PORTLAND MAINE

February 2, 2012

Re: 349 Stevens Avenue – 122 F002 – R-5 – illegal deck

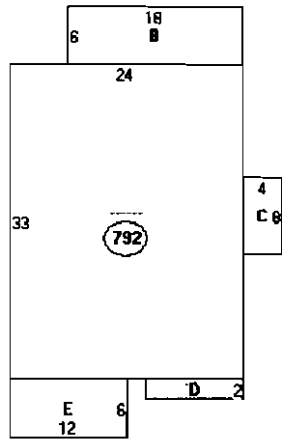
This letter is a follow up to the letter that I sent you dated June 14, 2010 regarding the fact that the existing rear deck was not permitted and does not meet the required minimum eight foot side setback [section 14-120(d)(3)(a)]. Since the deck is not permitted, it is illegal and needs to be brought into compliance.

You need to bring your property into compliance. You need to either apply for a permit to alter the deck to meet the zoning requirements of the R-5 zone or you need to remove it. You have thirty days from the date of this letter to make the deck legal. If the deck remains illegal after the thirty days are up, I will turn the matter over to our Corporation Counsel and they may begin legal proceedings to bring your property into compliance.
